City of Albuquerque Stormwater Construction Site Inspection Report

Project Name:	Top Golf				
Location:	1600 Desert Surf				
Site Contact Name & Agency	Richard Breck Arco	ESC File No.	F16E003E1		
		NPDES Id. No.	NMR1001XF		
Inspection Date:	06/13/19	Start/End Time:	9:45/10:45		
CoA Stormwater Inspector:	Curtis Cherne				
Construction Phase:	grading, constructing retaining walls				
Type of Inspection:	<input checked="" type="checkbox"/> Regular	<input type="checkbox"/> Storm Event	<input type="checkbox"/> Post Storm Event >0.25"	<input type="checkbox"/> 311/Complaint	<input type="checkbox"/> Follow Up

CONSTRUCTION EXIT

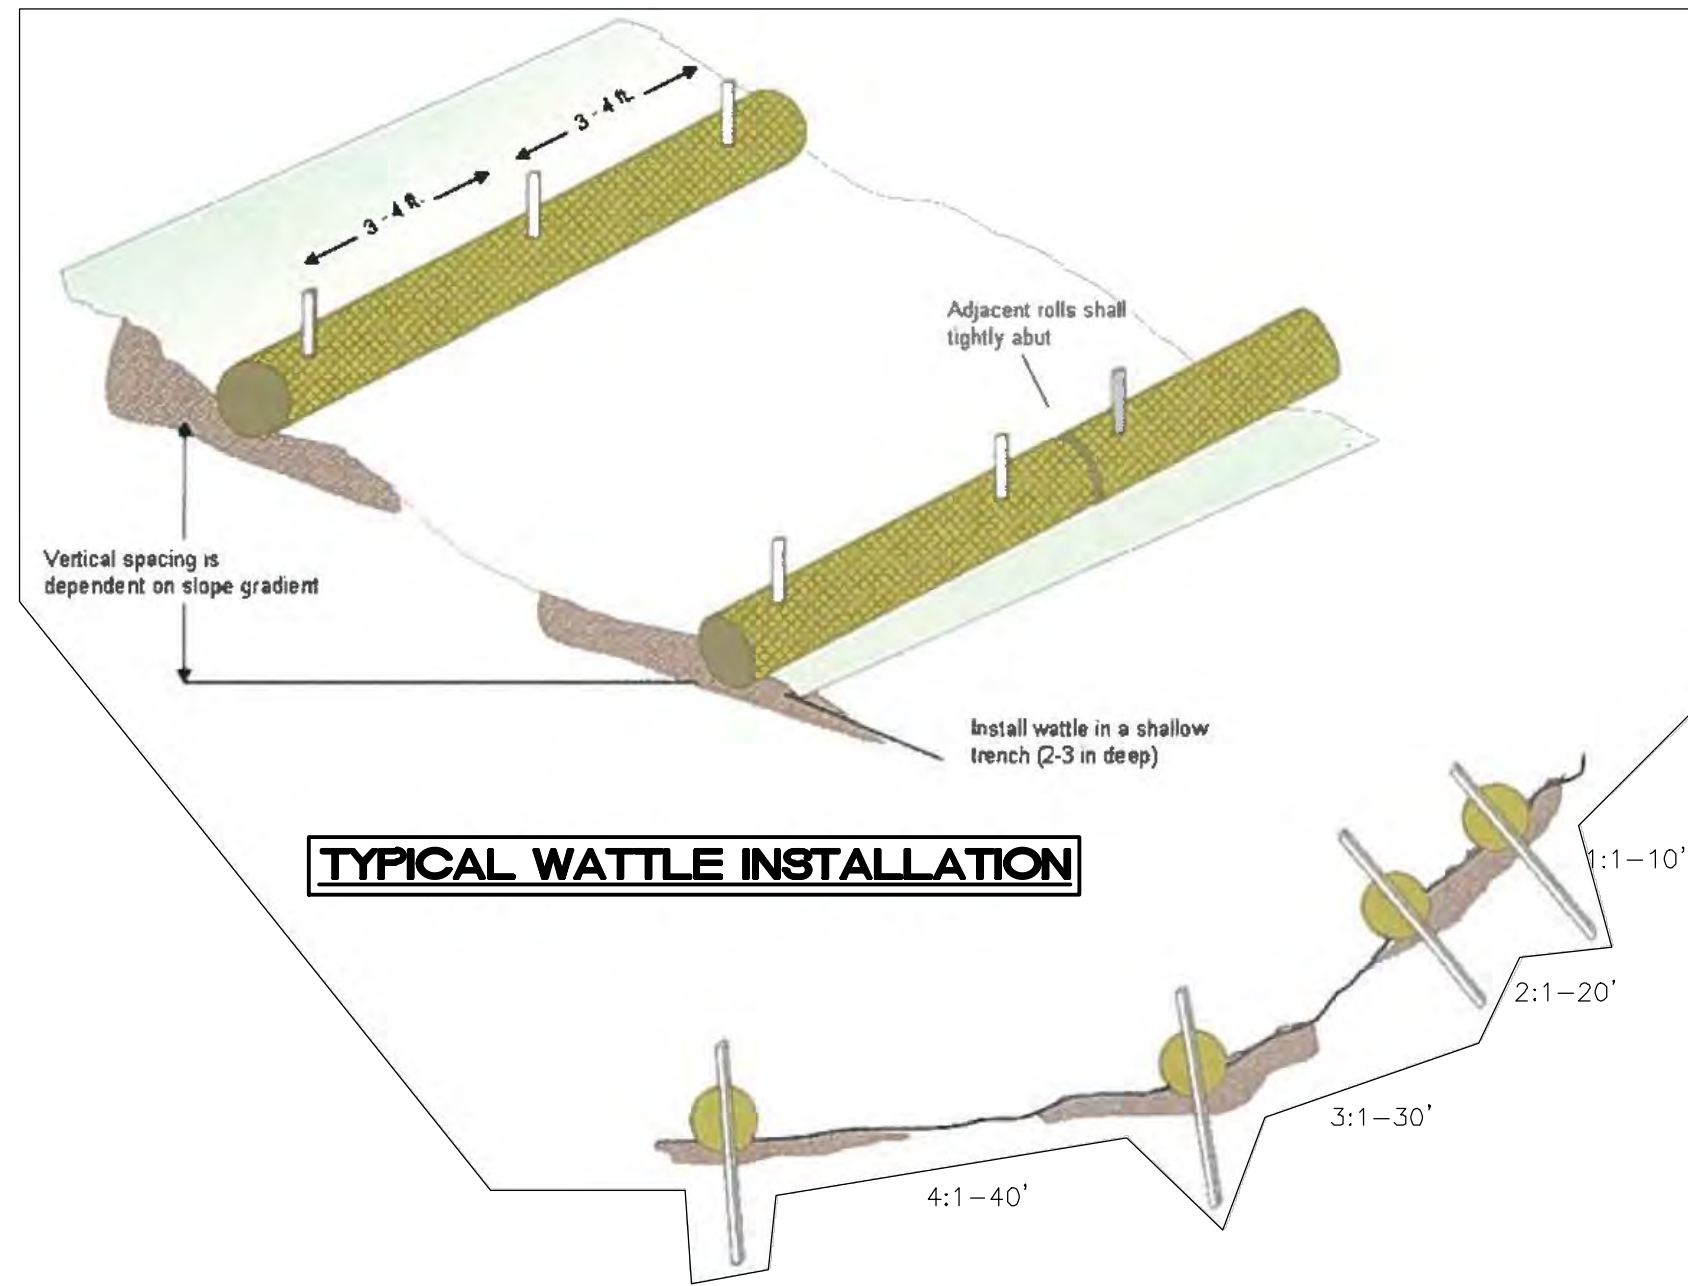
Item Number	Deficiency/ Corrective Action		
1	Too much sediment in street/gutter It appears the street is being swept, but the sediment is being swept into the gutter. Sediment in the street is to be removed (not just swept).		
2	Track-out pad aggregate is too small and there is a dirt area at the end of the track-out pad. Too small of aggregate size may not be providing enough bounce to remove dirt from the tires		
3	The inlet grate BMP on both inlets west of the construction exit are matted		
4	Wattle is falling into inlet (second from exit)		
5	Sediment on drivepad/sidewalk		
2.1	Discharge off site? (Y/N)	No	
4	Self Inspection Reports		Latest report Date: 6/5/2019

GRAVEL CURB INLET SEDIMENT FILTER

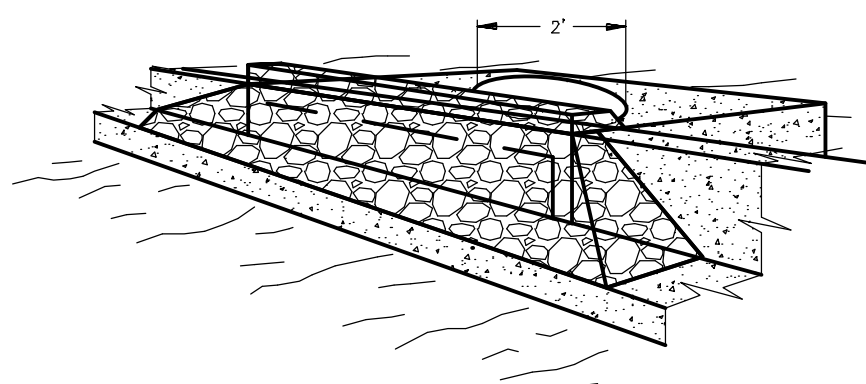
Notes:	
watering site during inspection	
recommend using filter/mulch socks rather than straw wattles to protect the inlet throats
